Application No: FG/34/21/HH
Site Address: 50 Ocean Drive Ferring BN12 5QP
Description of works: 1st floor side extensions, two storey front extension, side and rear extensions, installation of balcony to rear and 2 x front dormers including demolition of existing garage.

Thank you for your internet representation made on 28th March 2021 which has been recorded as an objection with the comments as follows:

With respect to planning application FG/34/21/HH I regret the need to object to the proposals on a number of grounds.

REAR (w)

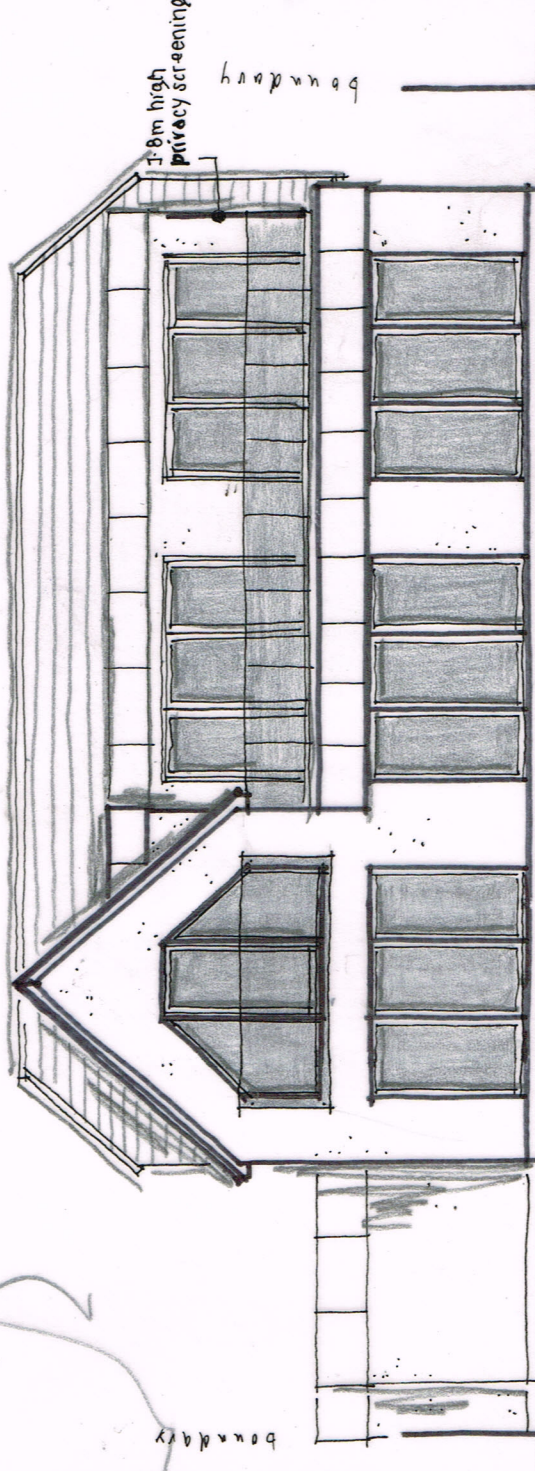
- 1). The proposed extensions are significantly out of proportion to the host building and in no way could the proposals be considered subservient to the existing building with the proposal building out in almost every direction on a small plot of land
- 2) the proposals would result in an overbearing property within its existing surroundings and neighbouring properties on all sides of the proposed development
- 3). The proposed building would result in a major loss of privacy for all surrounding buildings with it overlooking many private rear facing gardens
- 4) This overlooking exacerbated by the rearward (west facing) extension into the plot's garden (and the new first floor level) and a large balcony which will dominate the street scene and deny neighbouring properties privacy
